Sea Link (EN020026)

Final Supplementary Submission

Site Selection Proportionality, “Closest Suitable Location”, and Whole-Life Risk

Scheme: SEA LINK  
 Document Title: KENT CONVERTER SITE OPTION AREAS

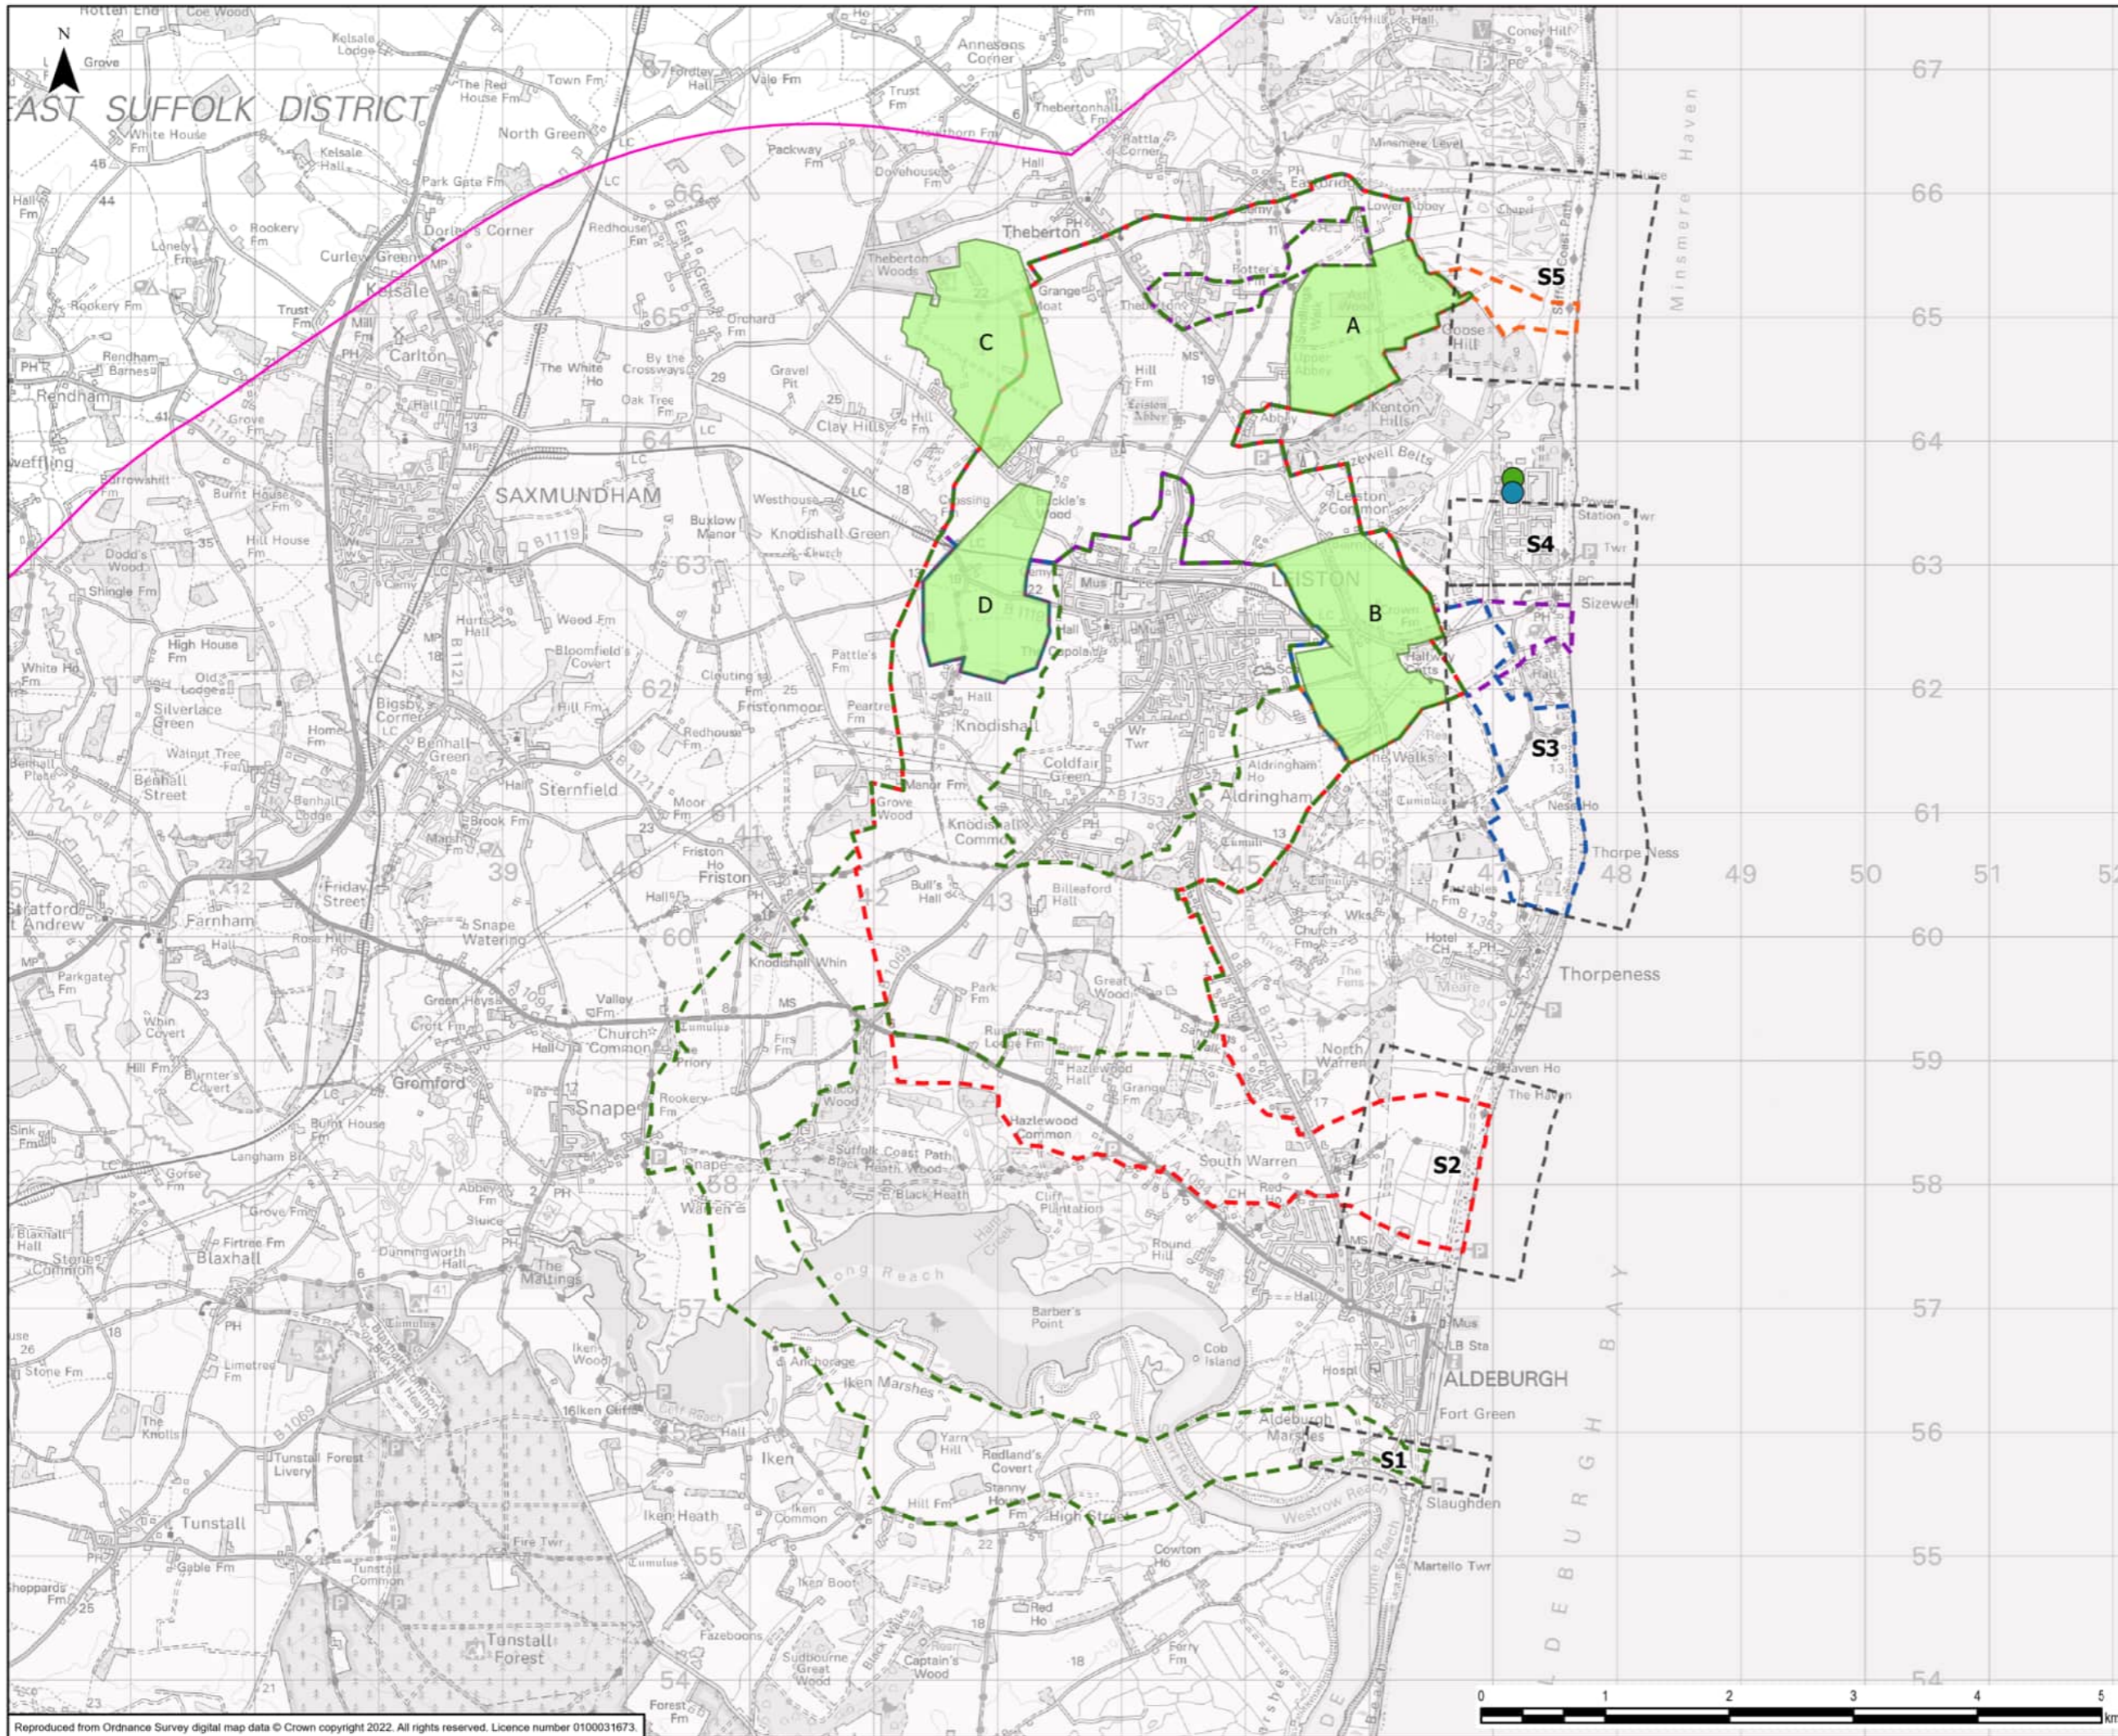
The Applicant’s *Main Alternatives Considered* chapter identifies Richborough (Area A) as initially preferred, citing shorter HVDC and HVAC routes.

The Examination would benefit from explicit clarification of what materially changed between the stage at which Richborough was preferred and the stage at which it was set aside.

- Earlier appraisal documentation described Richborough as enabling shorter HVDC and HVAC routes.
- No simple side-by-side distance table has been provided in the application documents.

Given that “closeness” is measurable, the Examination cannot assess proportionality without quantified data.

1. A quantified comparison table showing:
 - HVDC landfall-to-converter route length (km) for Minster and Richborough;
 - Converter-to-grid connection works length (km) for each option;
 - Total route-length differential.
 2. An estimate of CAPEX differential using the Applicant's own unit assumptions.
 3. A brief technical note clarifying:
 - Whether Richborough was excluded primarily for spatial, electrical or programme reasons;
 - Whether a compact layout solution at Richborough was tested against the consented BESS envelope.
 4. Confirmation that whole-life groundwater, flood and maintenance risk were explicitly weighted in the comparative appraisal.
-
